CITY OF ALBUQUERQUE

Re: Lone Sun Brewing
8111 & 8101 Las Lomas Dr. NE
Traffic Circulation Layout
Architect's Stamp 06-25-2021 (D16-D002M)

Based upon the information provided in your submittal received 06-28-2021, the above referenced plan cannot be approved for Building Permit until the following comments are addressed:

AS101/TCL

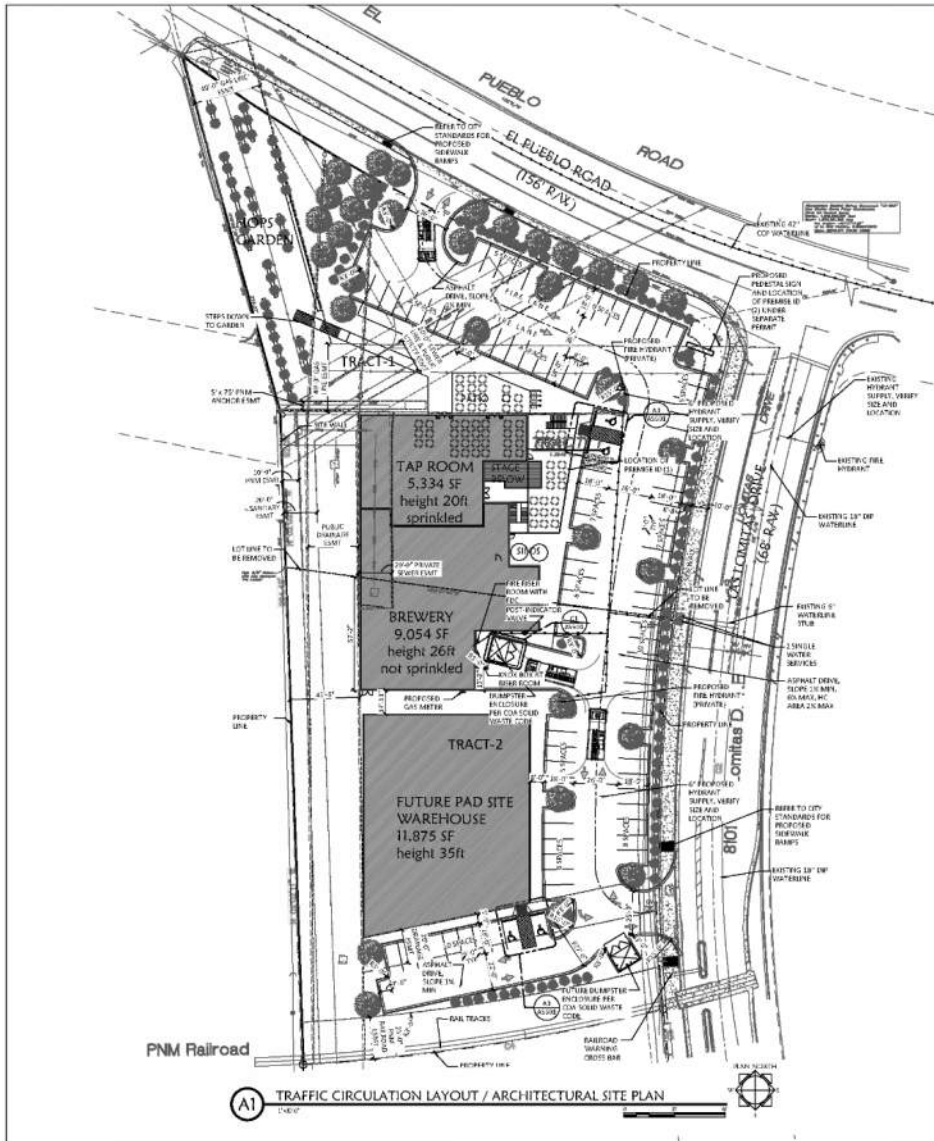
2. **El Pueblo Road:**
 - Provide the proposed sidewalk width and reference COA standards for the sidewalk construction/detail. Sidewalk along street should be placed at the property line.

- An ADA ramp will be required at the corner of with Las Lomas drive.
 - Future proposed Pedestal sign will need to be located on private property which includes air space (Please verify the location).

- Proposed private entrance: Provide standards and detail (include ramp detail with detectable warning surfaces).
3. **NW frontage segment off El Pueblo Road:** the segment appears to end at an opening of adjacent property. **Will a ADA ramp be required? If not provide a 6:1 sidewalk taper to ground elevation to avoid any tripping hazards.**

4. **Las Lomas Drive:**
 - Existing sidewalk width needs to be provided.
 - Proposed private details will need to be provided as well as ADA ramp with detectable warning surfaces.

- Is this a good idea for having a proposed private entrance so close to the railroad tracks and the pavement markings? Please address this concern.
 - Will need to contact Railroad to let them know that there is a proposed private entrance adjacent to the existing railroad tracks.

- There is an existing drop inlet at the proposed private entrance. Please coordinate with COA Hydrology section for this existing condition. **A WORK ORDER MIGHT BE REQUIRED.**

6. **Bollard Detail B5/AS501:** Paint proposed bollard yellow.
7. **Clarify existing property lines.** You have too many lines types not being defined in a legend. Make sure all private parking lot improvements are located on private property and not on **COA ROW.**

8. **Sheet AS501:** The ADA parking stall length as 20 ft but on sheet AS101/TCL the length is shown as 18 ft. Please address this concern.
9. ADA parking stalls show parking bumper plus curbing. Is this necessary? Explain?

10. Please list the width and length for all existing and proposed parking spaces. Some dimensions are not shown.
11. The minimum parking stall dimensions are:

18. Show all and radii. Some radii's are not shown.
19. List radii for all curves shown; for passenger vehicles. **Radius for delivery trucks, fire trucks, etc. is 25 ft. or larger.** Coordinate with FD.

20. **Per the IDO**, a 6 ft. wide ADA accessible pedestrian pathway is required from the public sidewalk to the building entrances. **Please clearly show this pathway and provide details.**

21. **Per DPM**, a 6 ft. wide ADA accessible pedestrian pathway is required from the ADA parking stall access aisles to the building entrances. **Please clearly show this pathway and provide details.**

22. You proposed ADA parking stall and access aisle do not support the 6ft pathway width requirements (proposed width shown as 5'-9"). The ramp transitions/wings are also an obstruction to the pathway. Please address this issue/concern.

23. Provide a copy of refuse approval for the proposed location of both dumpster enclosures.
24. It is not apparent what type of pavement surface is being proposed. A hard driving surface will be required as part of this proposed project for parking area and drive aisles. **You stated asphalt drive. Does this include all the parking lot? If please label as such.**

25. Please provide a sight distance exhibit will be needed at the Las Lomitas Drive northbound lane as well as mini clear sight triangles at proposed private entrances.

26. Show the clear sight triangle and add the following note to the plan: "Landscaping and signage will not interfere with clear sight requirements. Therefore, signs, walls, trees, and shrubbery between 3 and 8 feet tall (as measured from the gutter pan) will not be acceptable in the clear sight triangle".
